Please include project No. PPR2428

PURPORTED STREET ADDRESS:
9025 Chicago Avenue
 DATE: 3/8/2023
 CLIENT: Mierkey
 JOB NUMBER: 231076

v1_Site Development Plan - REDLINES.pdf Markup Summary

Scale: 1" = 60'

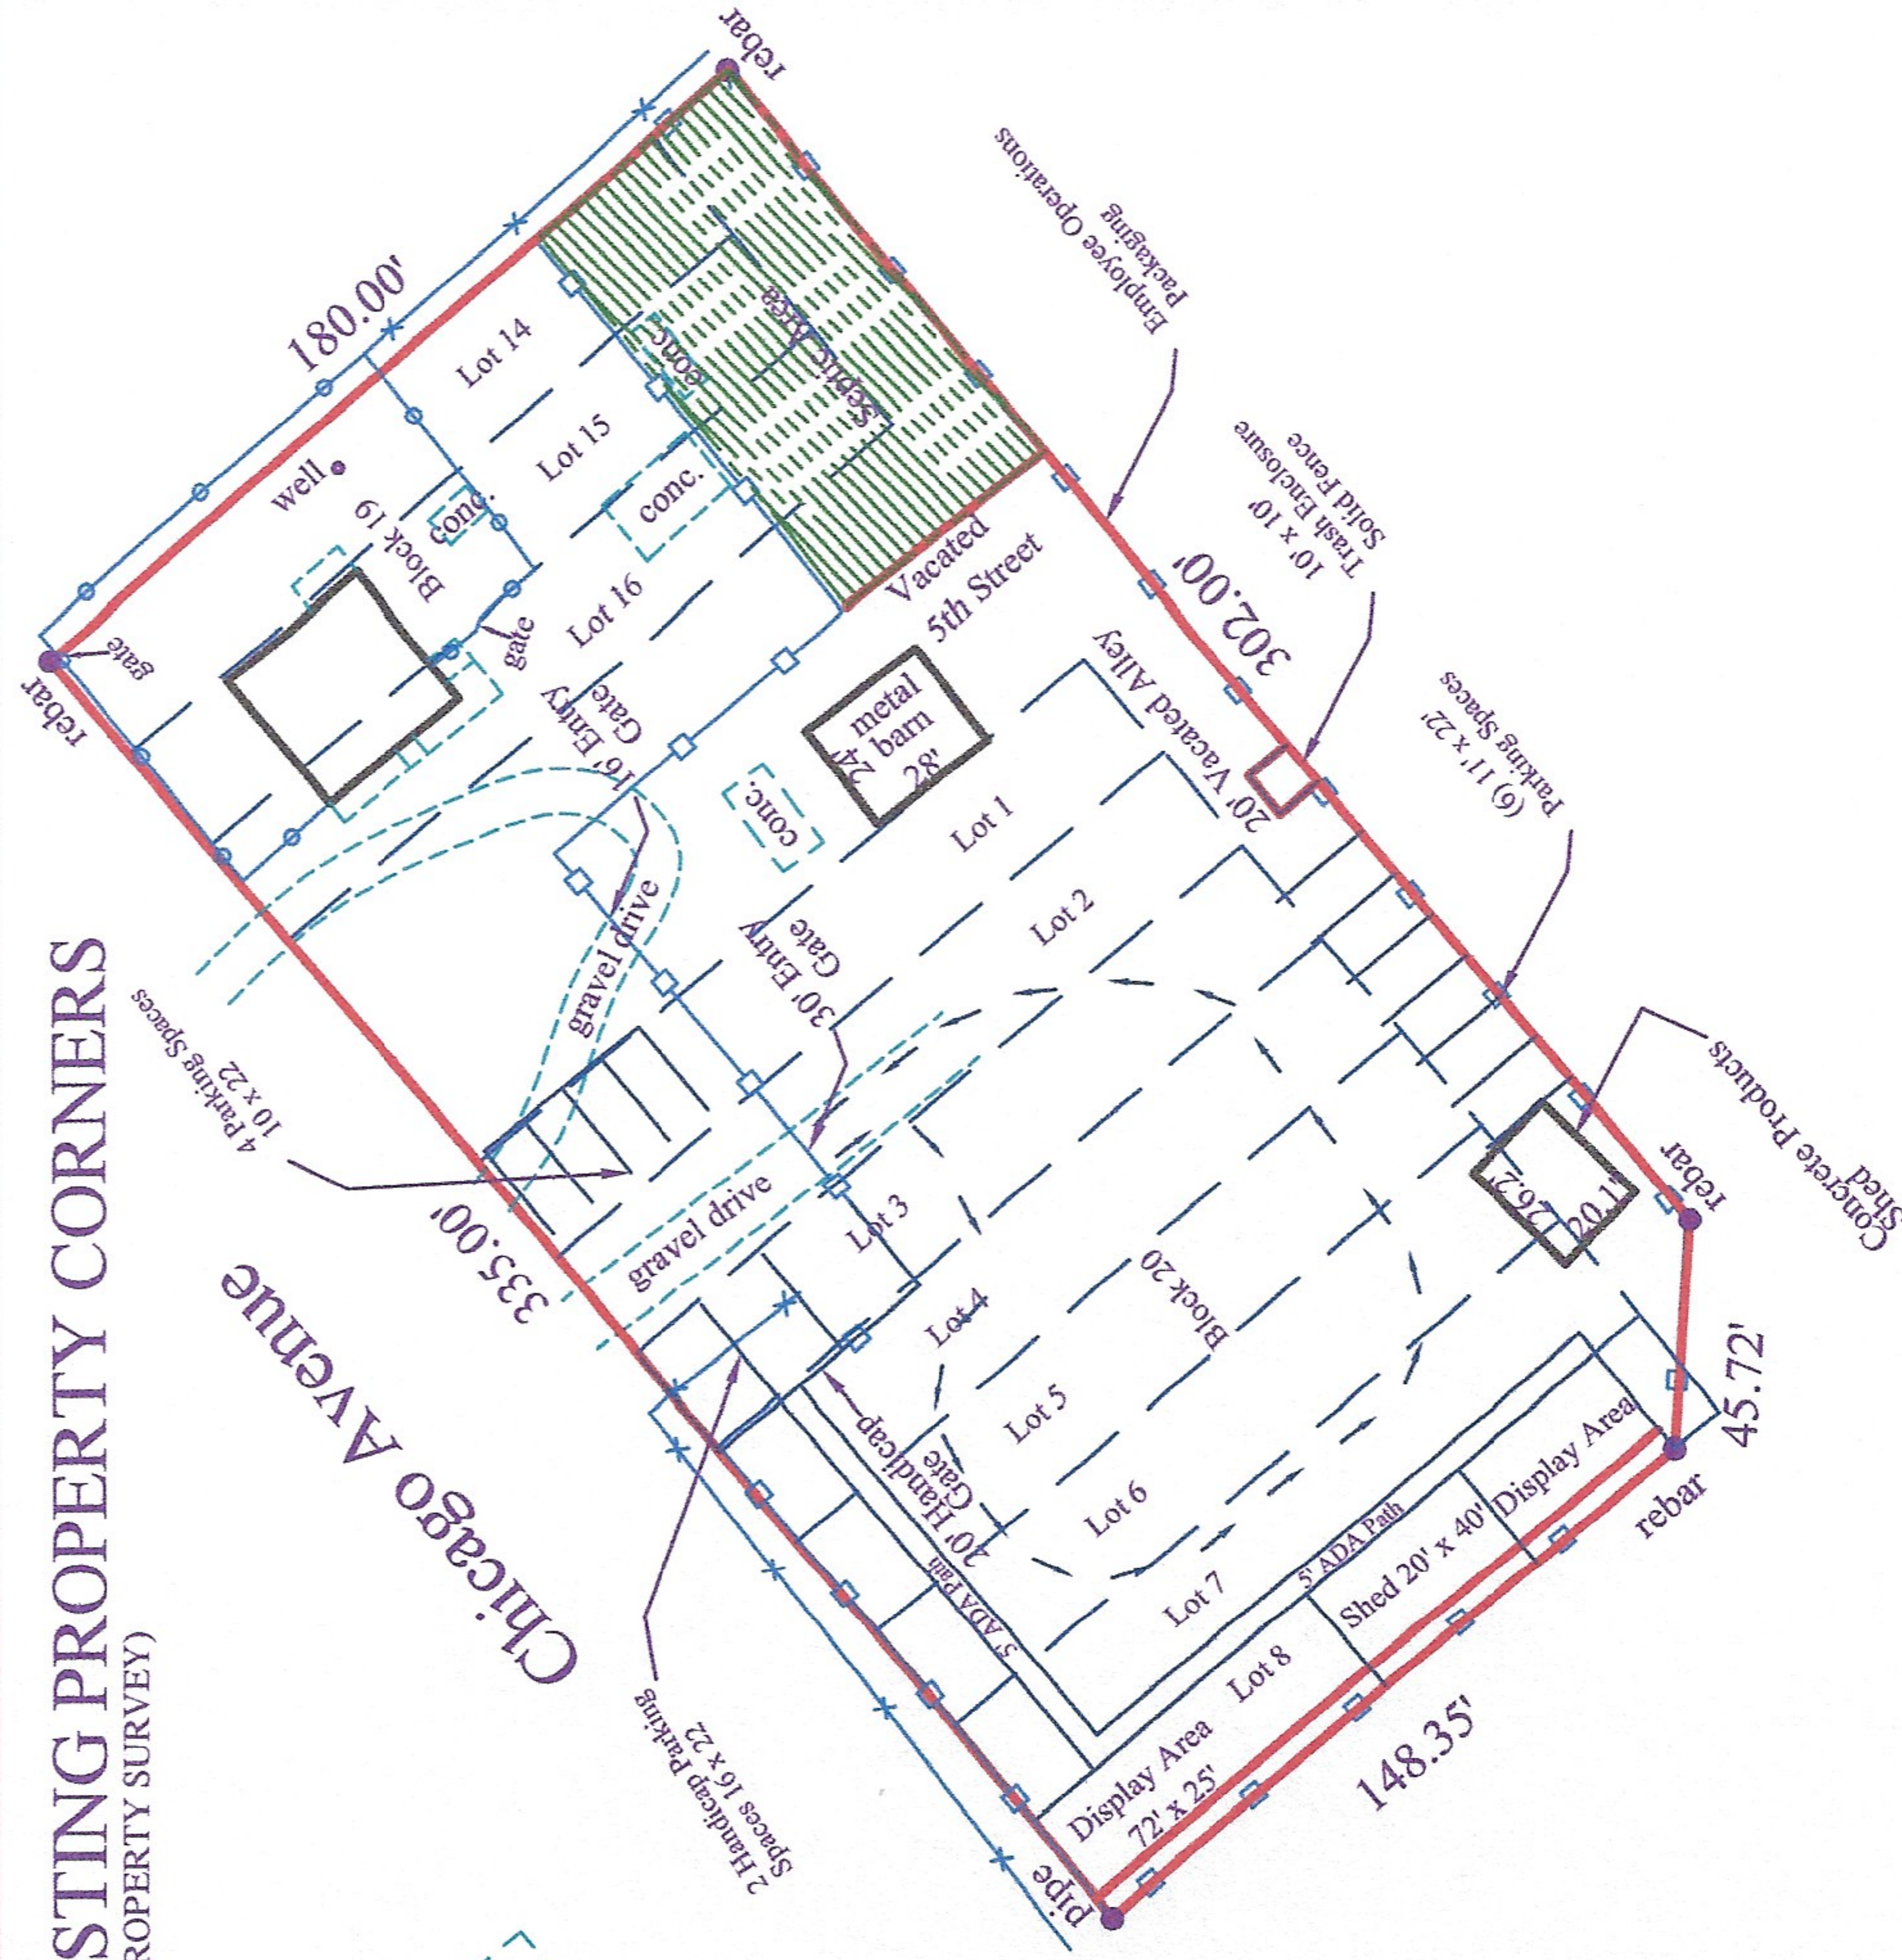
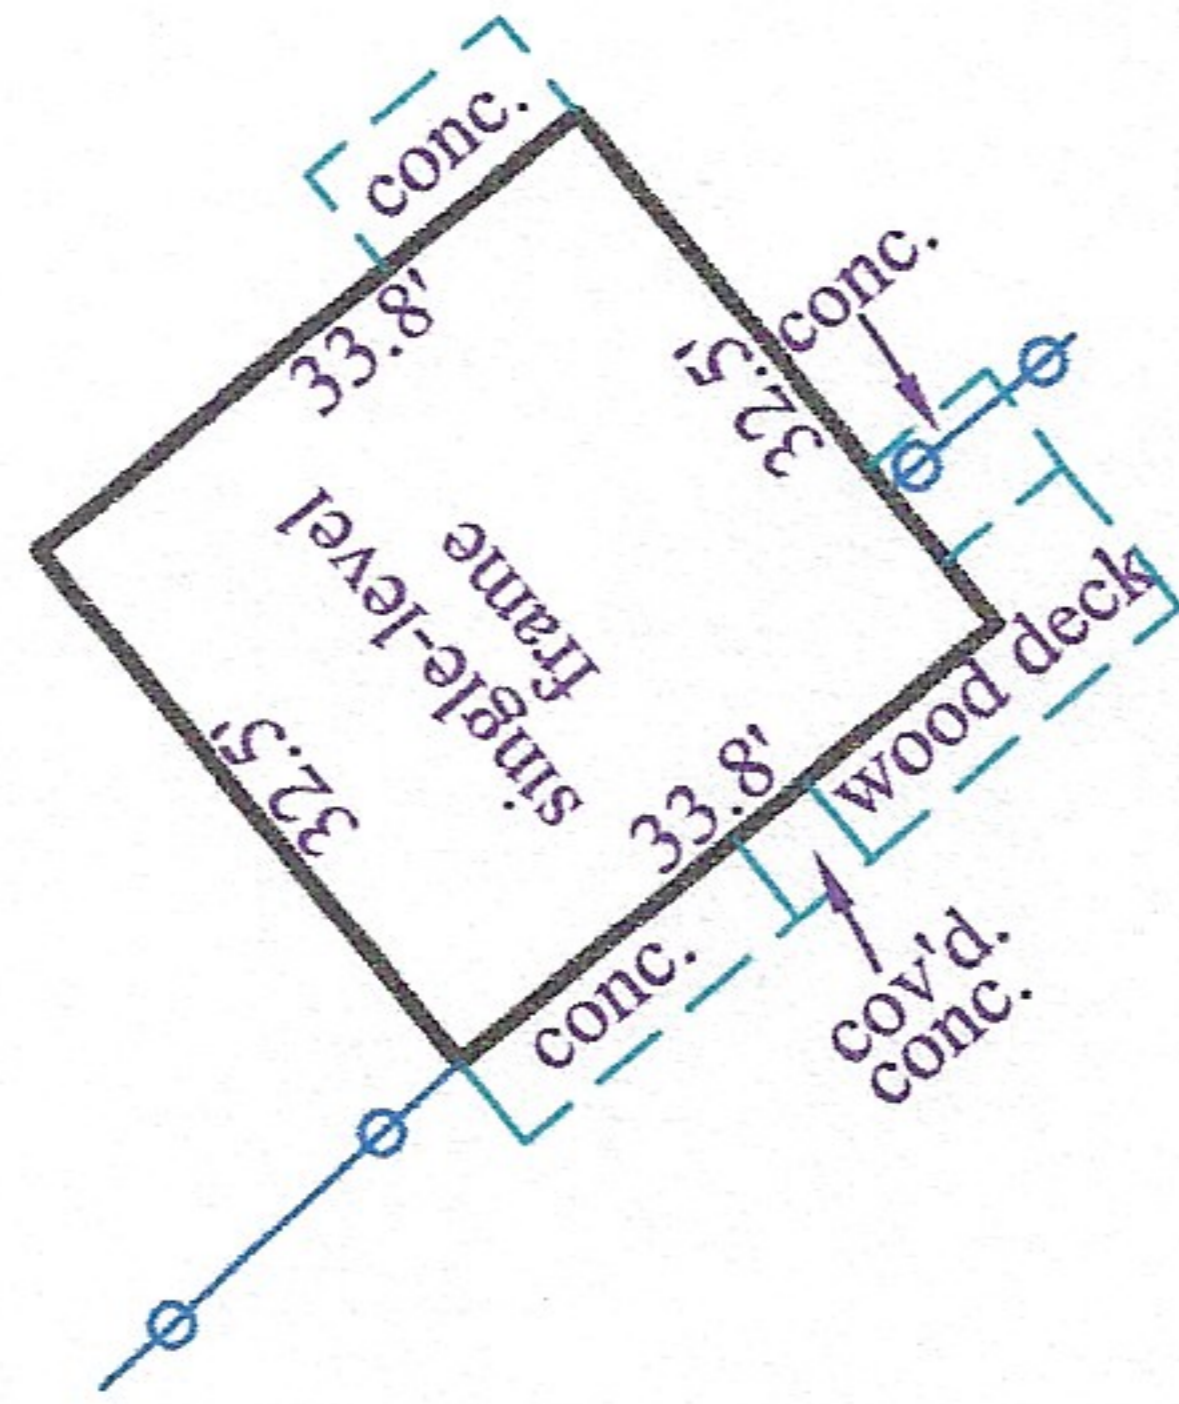
Include a scale.

Show where the sign will be located on the fence.

Show where landscape areas are to be located.

Show location of existing water infrastructure.

Provide setback distances from each structure to the property lines.

Please include a vicinity map.

Clarify what is existing and what is proposed. The drainage report states that the only change is to add a 20'x40' shed but the letter of intent and this plan seem to indicate more proposed work. It needs to be clear throughout what is existing and what is proposed. We need to know the total site disturbance.

Provide height of all fencing on the site.

Please call out this roadway (ownership, ROW) Public or private
